**Consultation Response from KC,
Lead Local Flood Authority**

2023/91212 Land off, Bankfield Drive, Holmebridge, Holmfirth, HD9 2PH

Erection of 16 dwellings with access from Laithe Avenue

Date Responded: 26/05/2023.

TITLE
S104 DRAINAGE LAYOUT PLAN

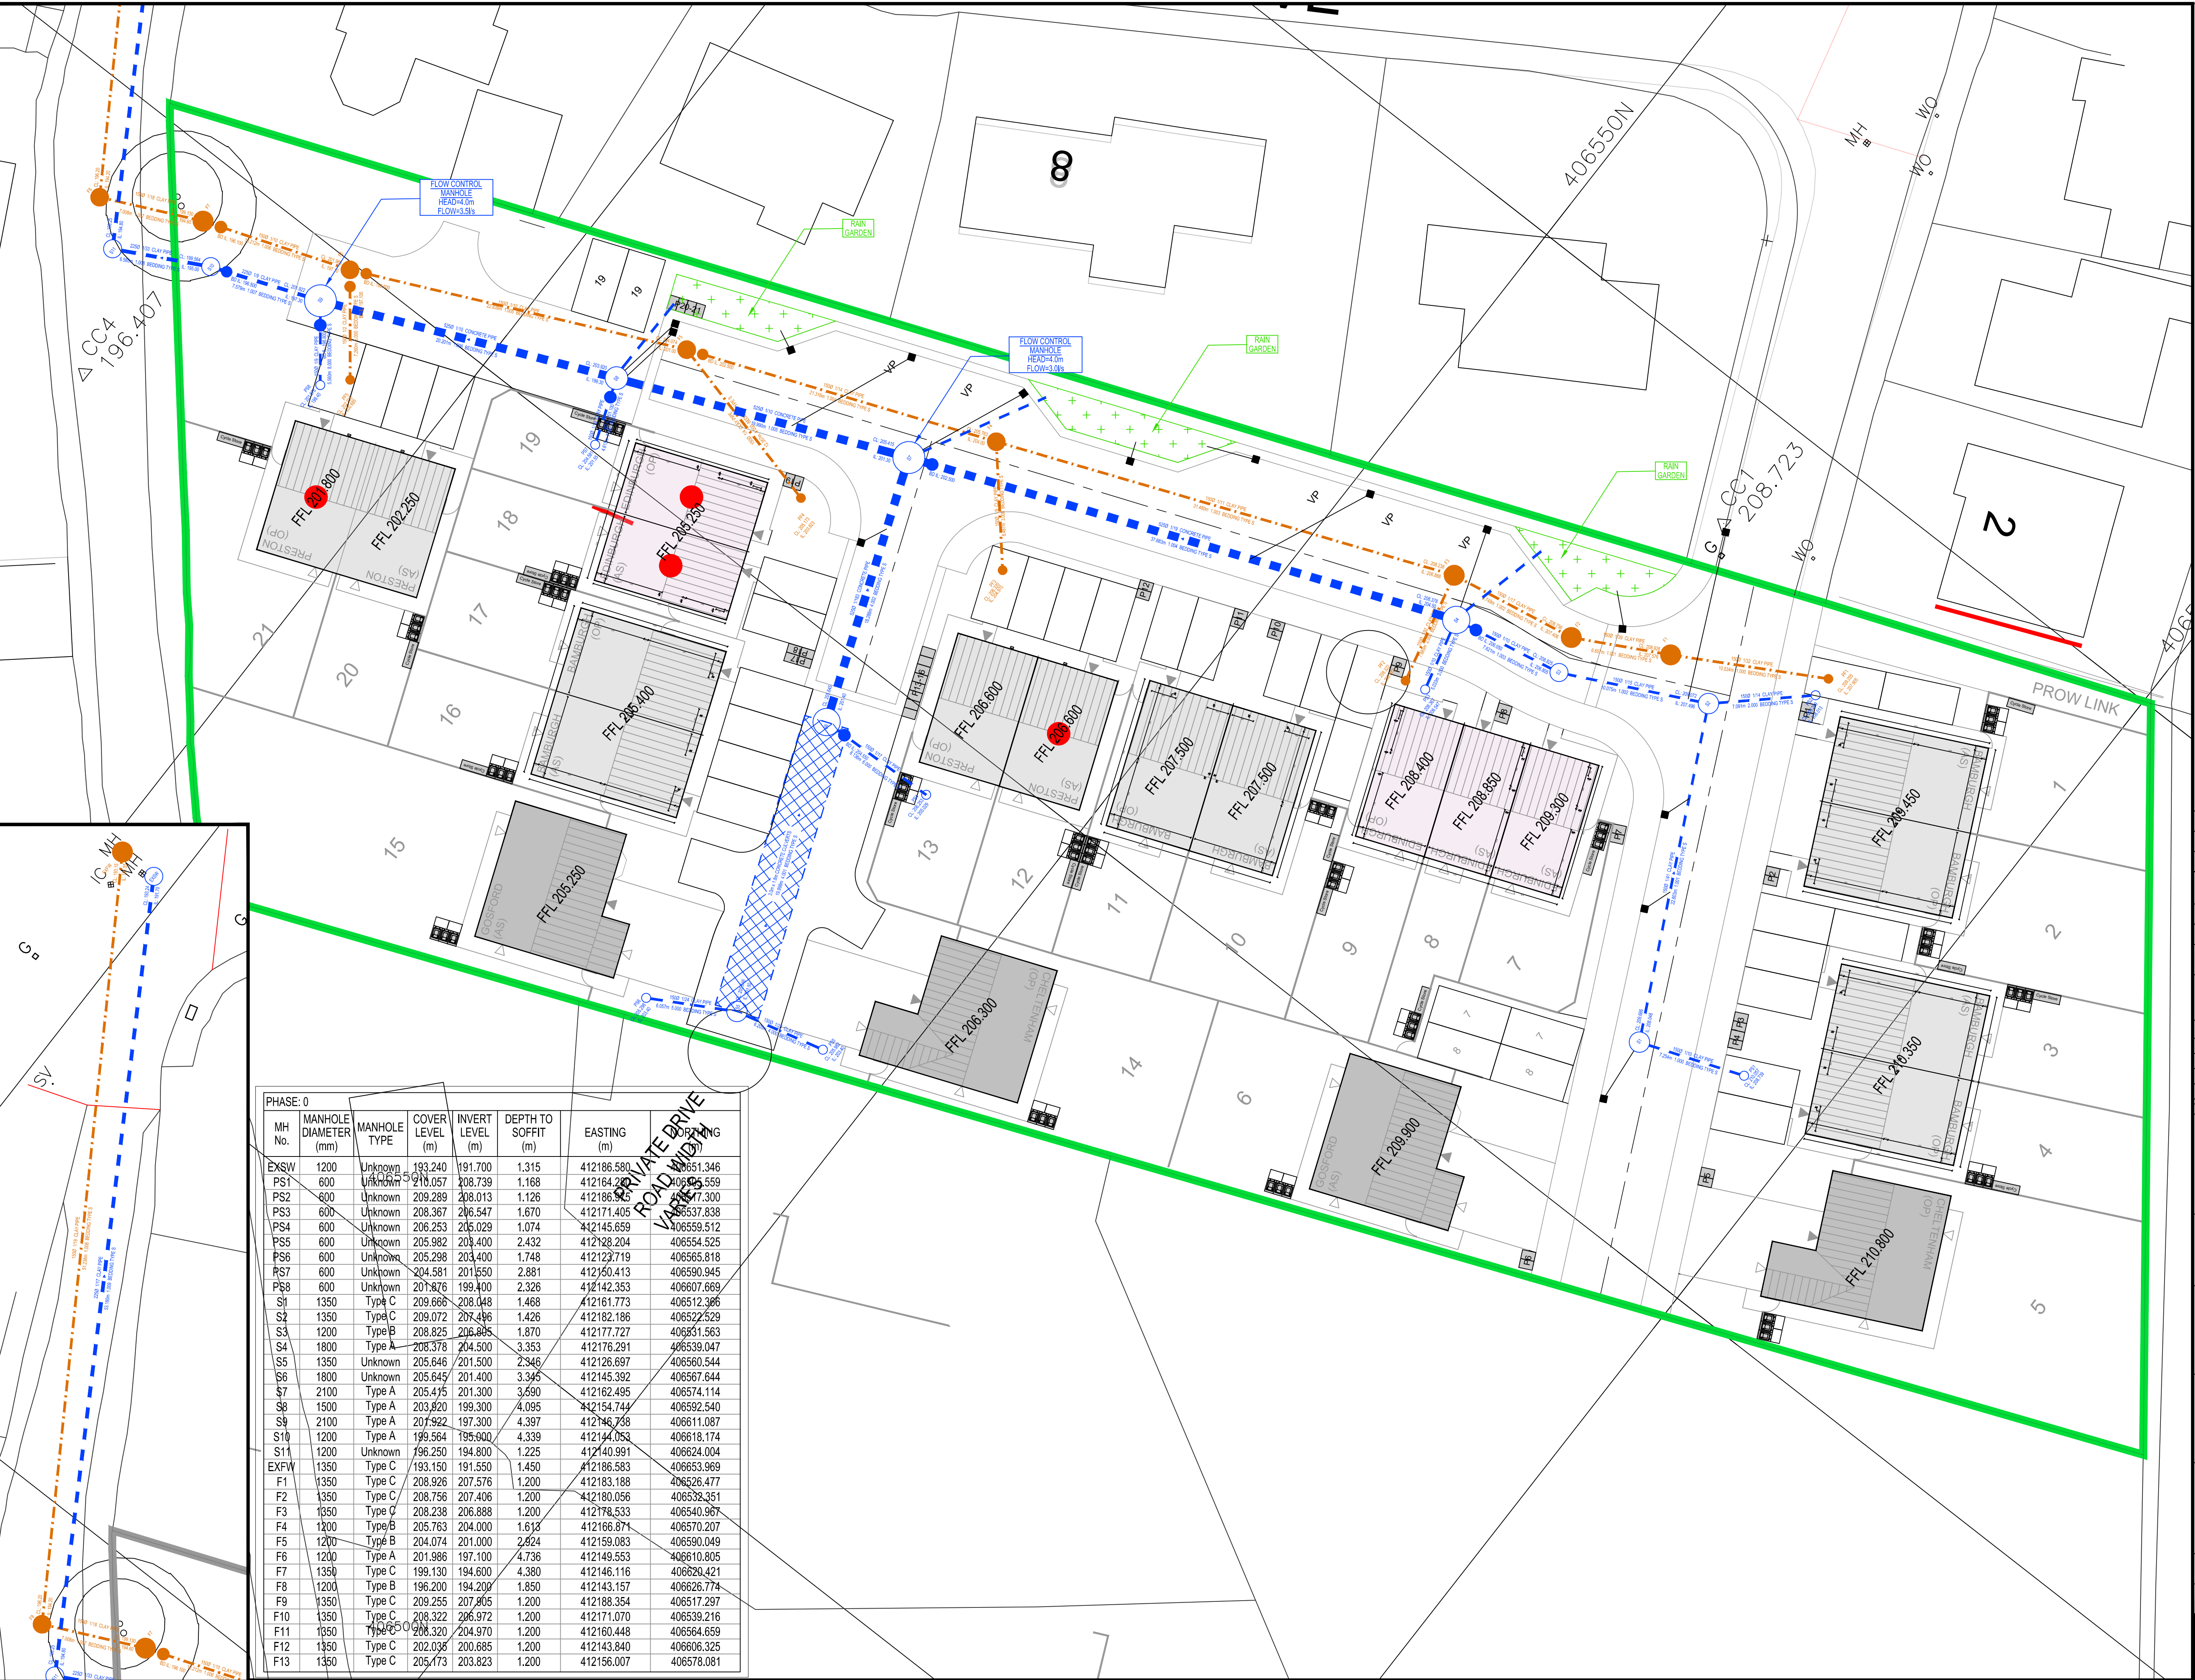
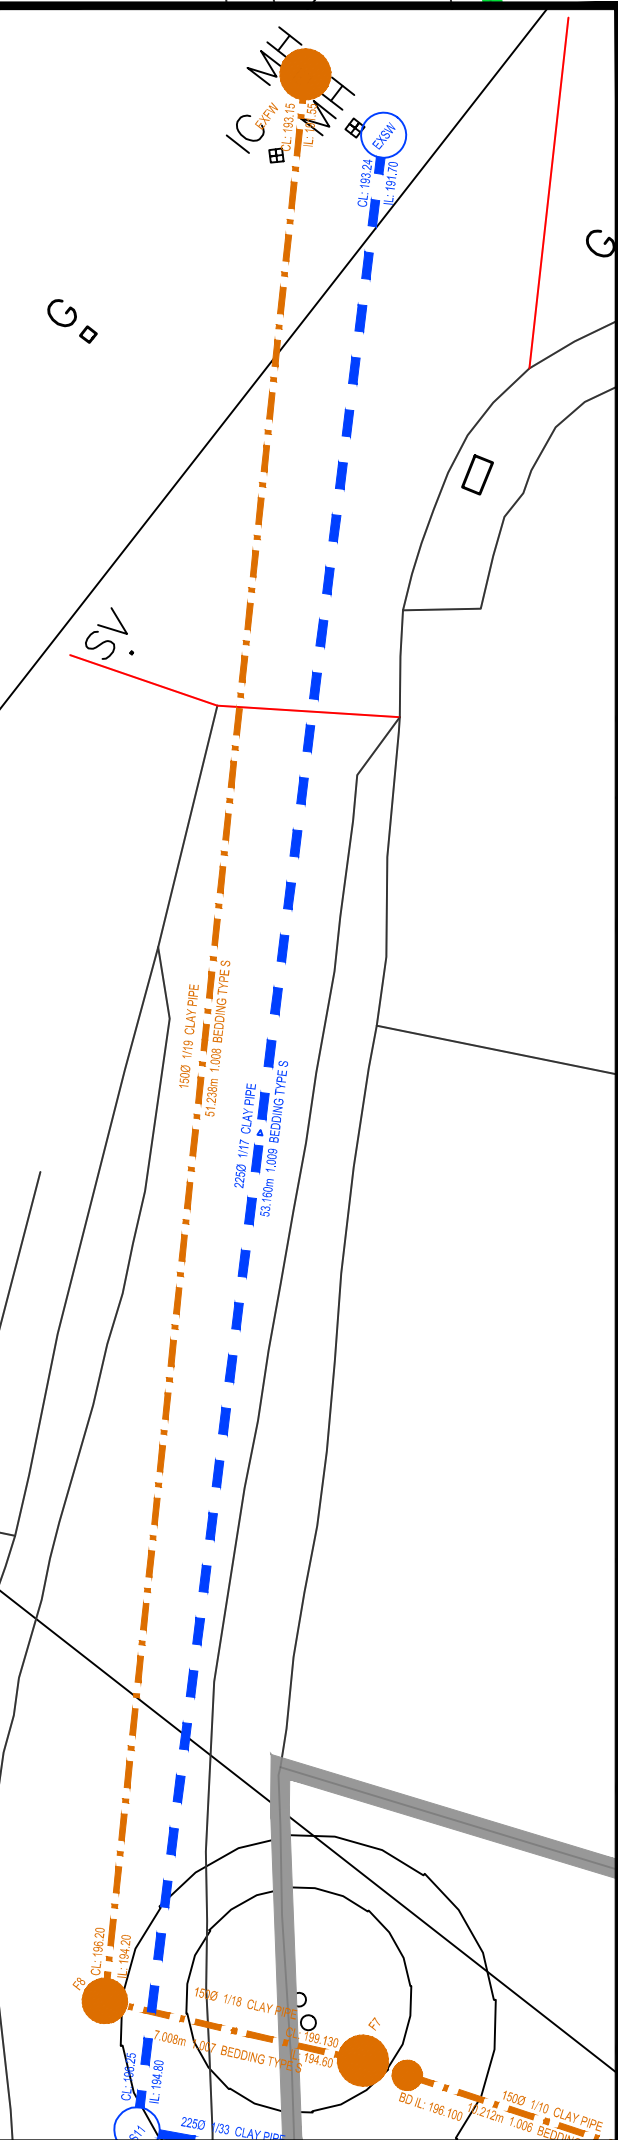
The LLFA does not accept the proposed allowable surface water discharge rate of 8.8 l/s as shown on the Drainage Layout Plan.

The flow rate must be limited to the equivalent greenfield run-off rate of **5.0 l/s per ha** of impermeable drained area subject to a minimum flow control outlet of 75mm.

The developer proposes to attenuate surface water flows from individual houses each with a small tank with outlets restricted to very low flow rates. The LLFA has concerns that the outlet restrictions would be of very small diameters that would become easily blocked. The developer is reminded that Part H of the Building Regulations (Section 3.14) limits the diameter of surface water drainage pipes to a minimum of 75mm.

The developer will need to state how these tanks/outlet controls will be maintained in the long term.

Hydraulic calculations will be required to prove that the surface water attenuation tank volume will be sufficient to prevent run-off from leaving the site or increasing flood risk to existing/proposed properties for the 1 in 100 year (plus climate change allowance) rainfall event.

The LLFA's preference would be for a single surface water attenuation tank serving the whole of the site located at the lowest point on the surface water system prior to the discharge off-site into Dobb Top Road. This tank and its associated flow control device would then be maintained under a Maintenance Contract or adopted by the Sewerage Authority (subject to SA approval).

Kirklees Flood Management and Drainage as Lead Local Flood Authority, OBJECTS to this planning application and requires that a revised surface water drainage strategy is submitted taking into account the reduced allowable discharge rate as stated above and FURTHER INFORMATION is provided regarding the maintenance of the drainage system.
